ABP— 322154-25

Townlands of Acragar, Ballyconra, Ballycuddihy, Ballyroe, Ballyroe (Grace), Ballyroe (Maher), Baunaniska, Boherkyle, Briskalagh, Brittas, Clone, Coolnapisha, Curraghduff,, Freshford, Freshford Lots, Graigueswood, Grange, Huntstown, Kilmanagh, Knockeenglass, Knockown, Moatpark, Monabrika, Monavadaroe, Moneenaun, Oldtown,, Oldtownhill, Parksgrove, Picketstown, Rathealy, Sart, Sweethill, Tobernapeastia, Tullaroan, Upperwood Demesne, Co. Kilkenny.

**PLANNING OBSERVATION
ON PROPOSED WIND
TURBINE DEVELOPMENT:
CONCERNS FOR
BALLYCALLAN GROUP
WATER SCHEME (GWS)**

Planning Application: 2560003 (Kilkenny County Council)

DRAWING TITLE:
Turbine 2 Layout

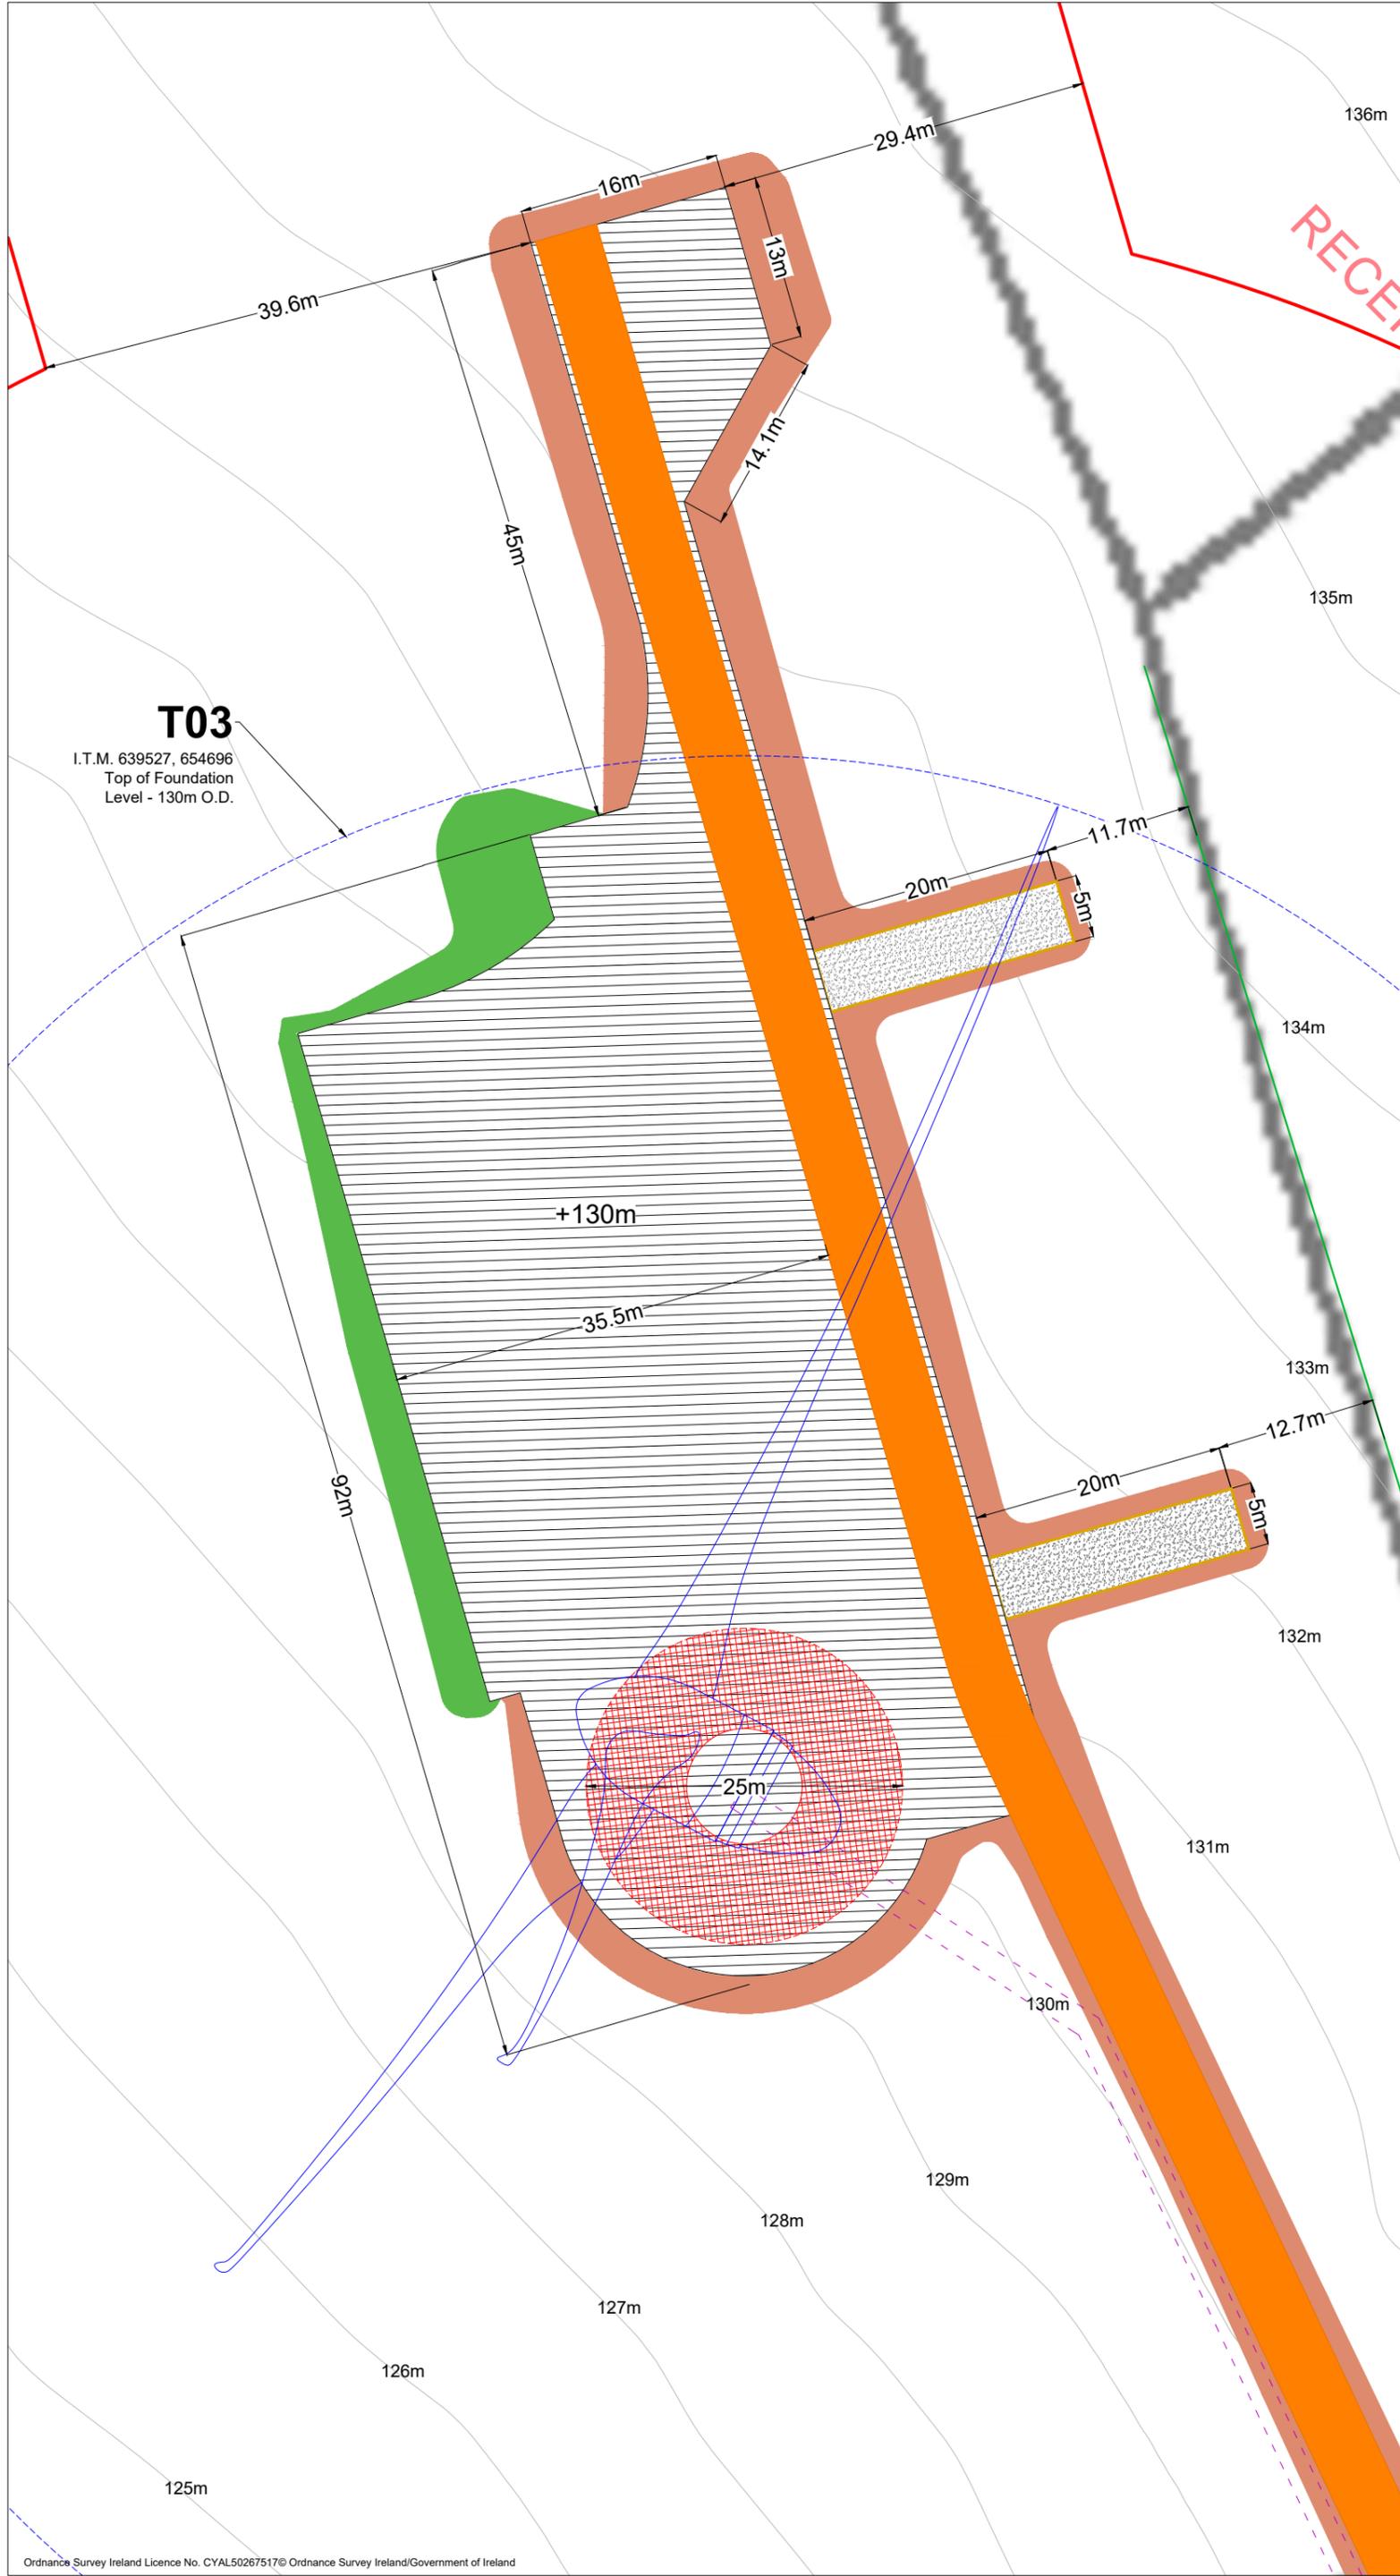
Turbines T01 and T02, as well as spoil management and borrow pits, are located in areas where pollutants could easily infiltrate groundwater.

The proposed development area lies within zones of high to extreme groundwater vulnerability, with particularly sensitive areas mapped for turbine installation, spoil management, and borrow pits. Geological Survey Ireland (GSI) vulnerability maps confirm that Turbines T01 and T02, as well as associated infrastructure, are positioned in zones where pollutants could readily reach the groundwater.
